Health

Our Ref: H20/64462

**RE: Sydney Metro West Environmental Impact Statement (SSI-10038)**

Figure 1: Overview of the cumulative impact assessment methodology

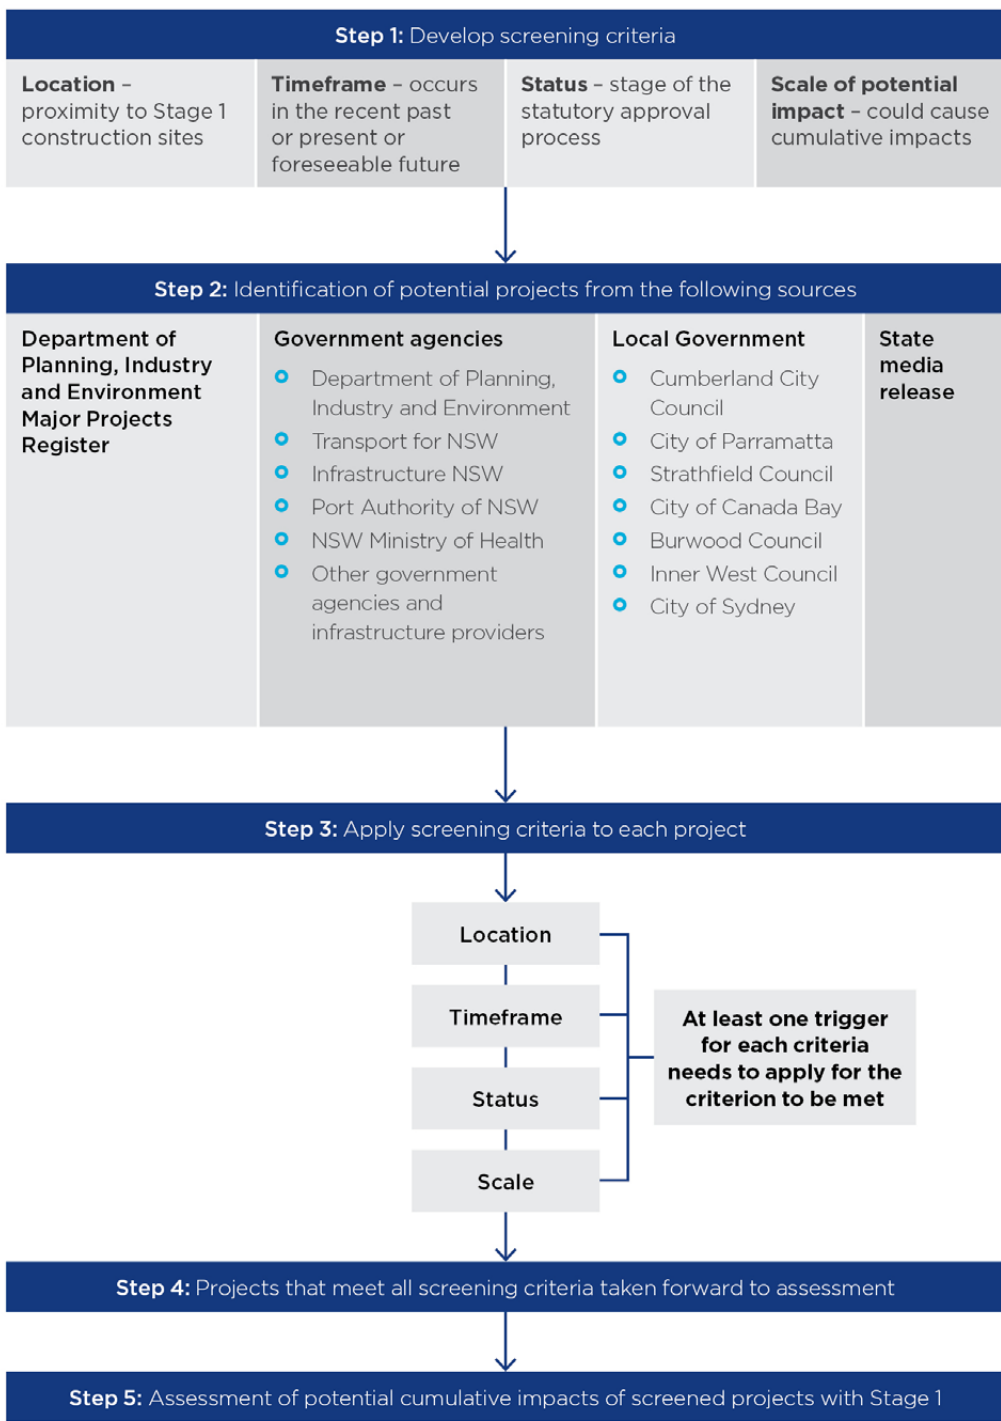
The screening method (Appendix G) to identify cumulative impacts from construction of concurrent or consecutive projects is appropriate. Some communities in the vicinity of the project have experienced construction activities from other projects over a number of years. Cumulative impacts can increase the vulnerability of people in those communities. Consideration should be given to providing additional mitigation measures where communities have recently been impacted by other construction activities.
